Subject: RE: White Cottage (WA/22/19/PL)

Engineers Comments Regarding Surface Water Drainage

Drawing B16b August 2018 Scale 1:20 & 1:100 @ A1
Building Regulation Drawing - Externals Plan

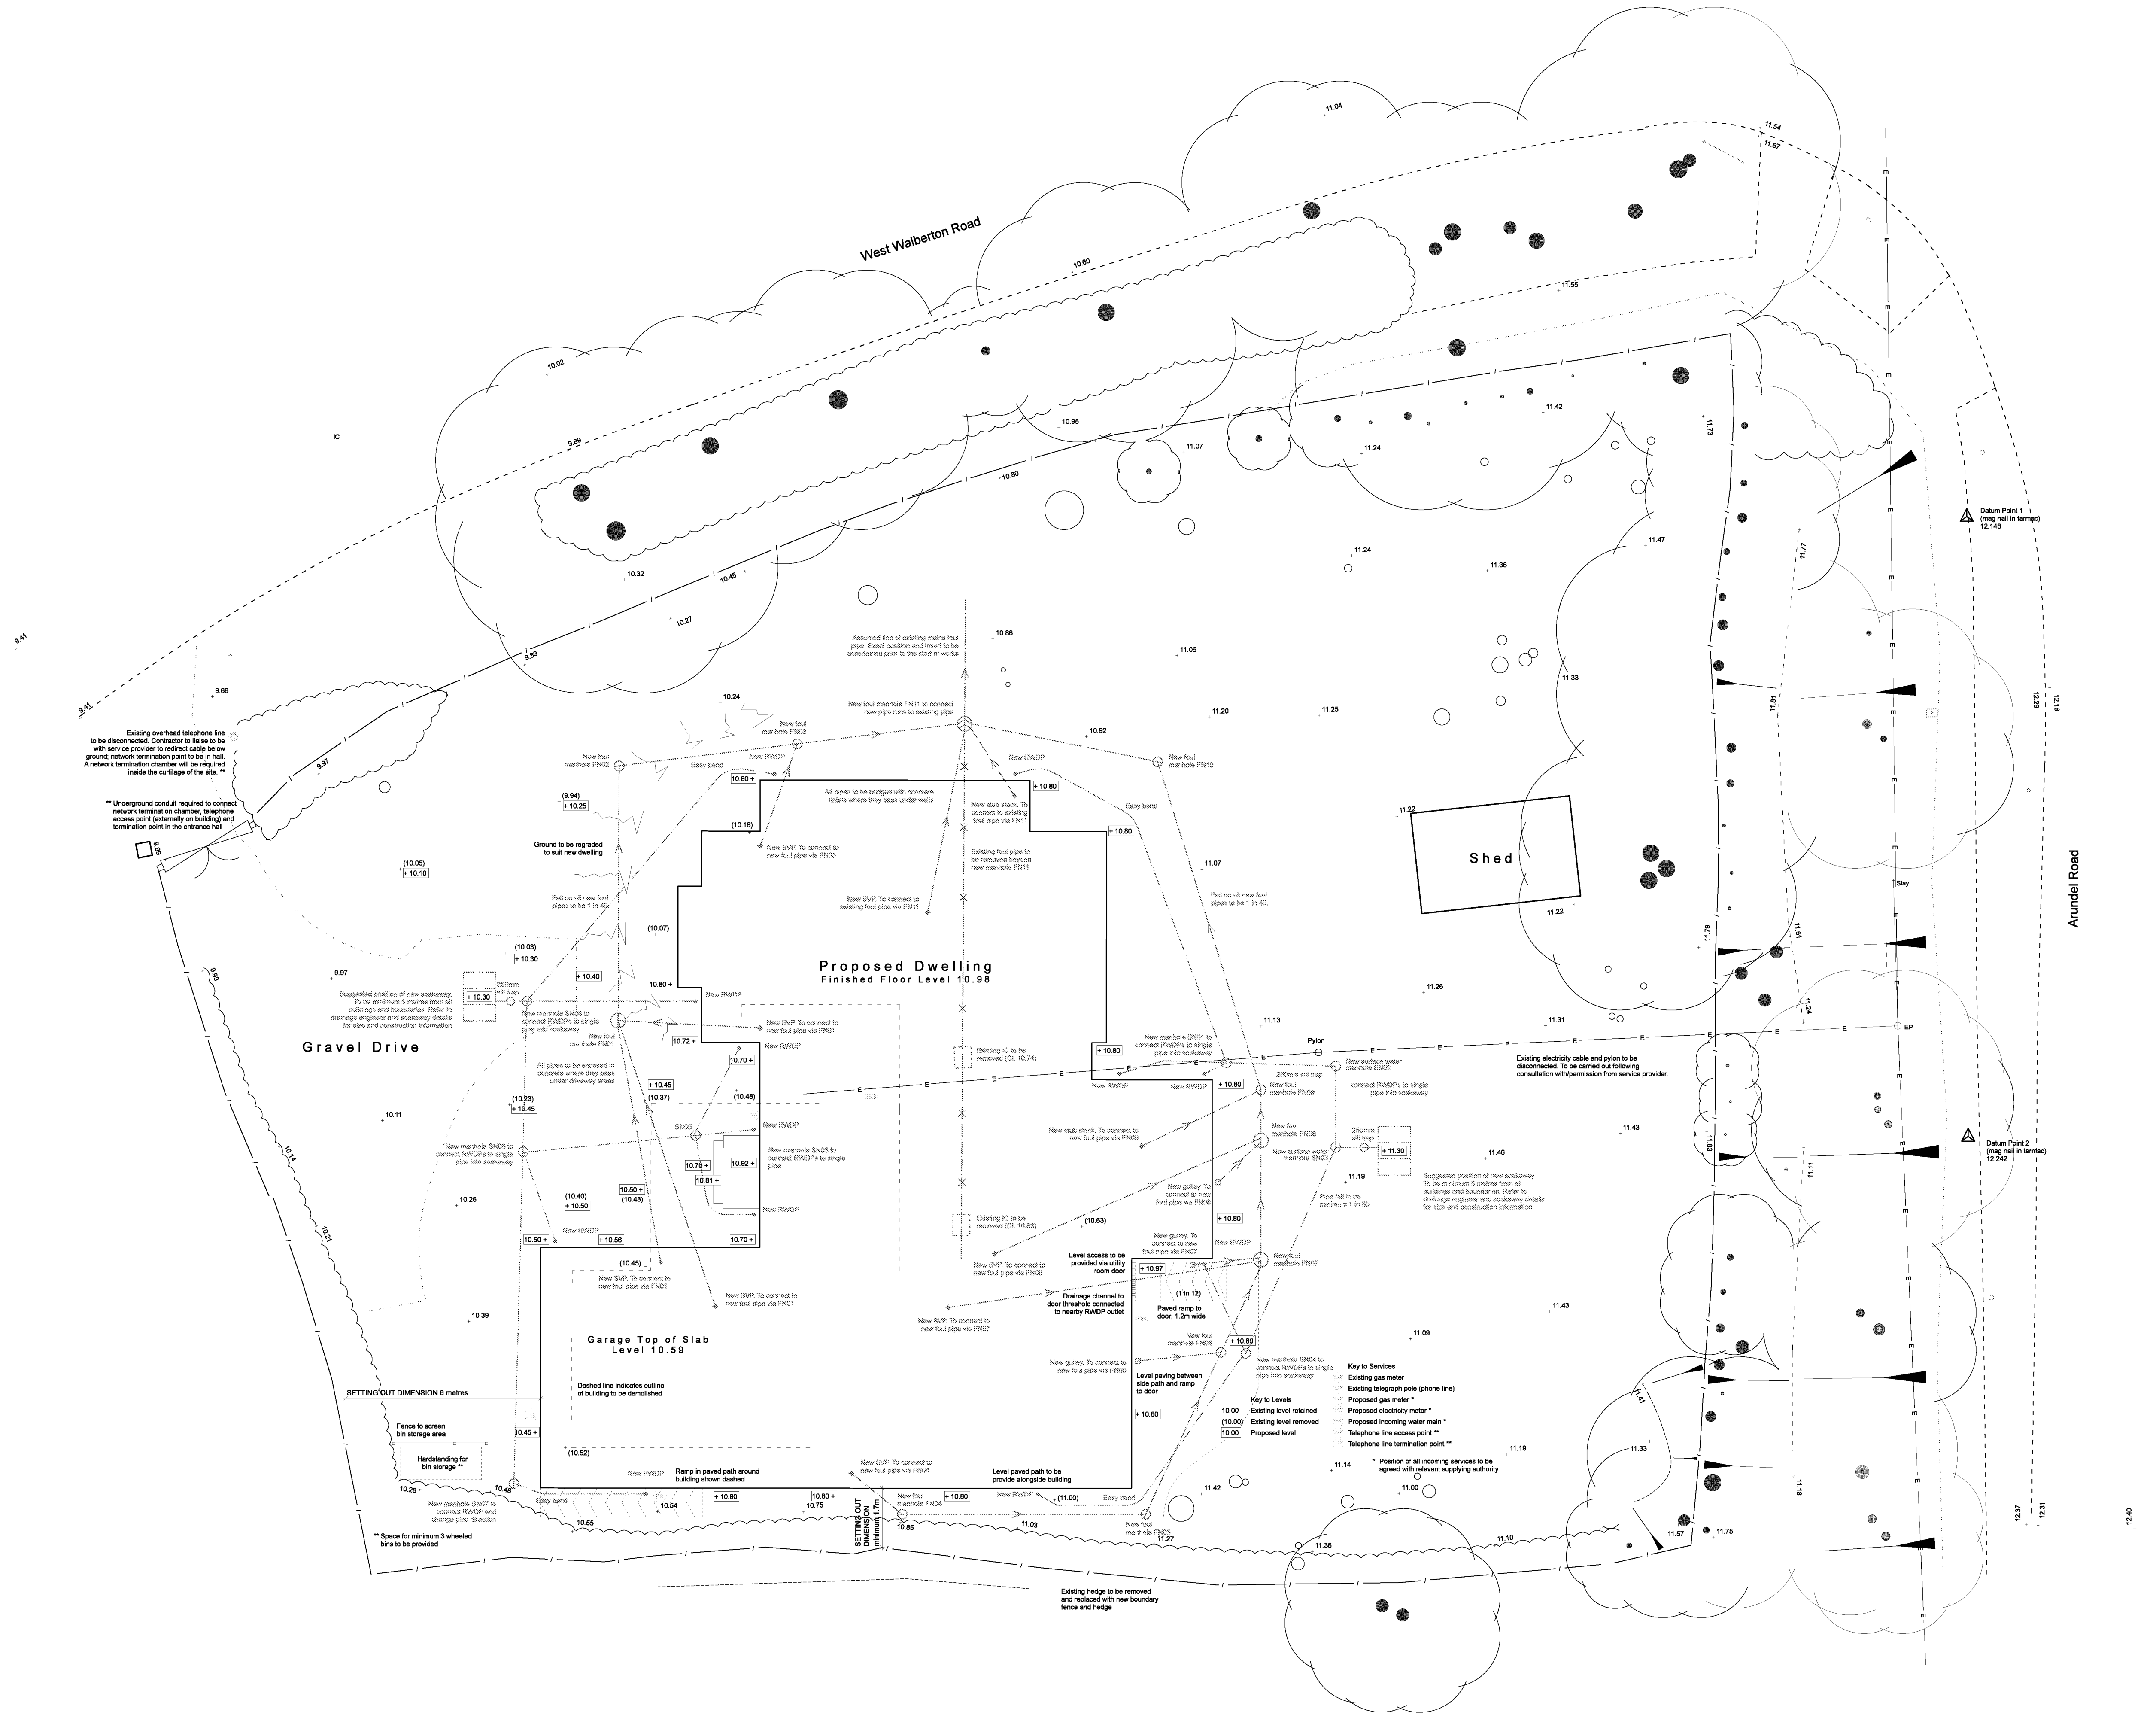
Thank you for the updated drawing. I appreciate that the extra level of crates have been included to compensate for the lower pipe level. However I am aware that this will provide a soakaway of capacity beyond design criteria which will result in additional expense to the applicant in excavation and materials. I am happy to accept this drawing and recommend removal of the condition, however if you supply a drawing with a soakaway of three crates depth I will also accept this. I asked simply that the pipe be raised to the highest point possible which I am happy that you have done.

An additional layer of crates has been added to the soakaways to ensure that the invert is at least 1.2 metres below the incoming pipe.

I have looked at raising the level of the incoming pipes; the length of the longest incoming pipe to the rear soakaway is around 20 metres. At a fall of 1 in 80 and with minimum 300mm cover over the pipe, it is not possible to raise the level of the pipe where it joins the soakaway.

Whilst the fall and pipe lengths for the front soakaway would allow the incoming pipe to be at a similar level to the rear soakaway pipes, a minimum 710mm cover is required over the crates as they are positioned below the driveway. Therefore the best I can do is to raise the pipe to connect to the top of the highest crate, as shown on the amended details attached.

Please remove Laura Gibbon's former request for condition PCENG2 to be applied. If you are minded to approve the application please apply the following condition to ensure that the development is adequately drained and does not increase flood risk elsewhere.

The development hereby approved shall be carried out in accordance with the Drainage Drawing – B16f, and Soakaway Calculations (Revision E).

As suggested, please find attached a revised copy of drawing B16f, with the soakaway reduced to 3 crates deep. I request that this drawing is uploaded to the planning portal and accepted as the agreed surface water design.
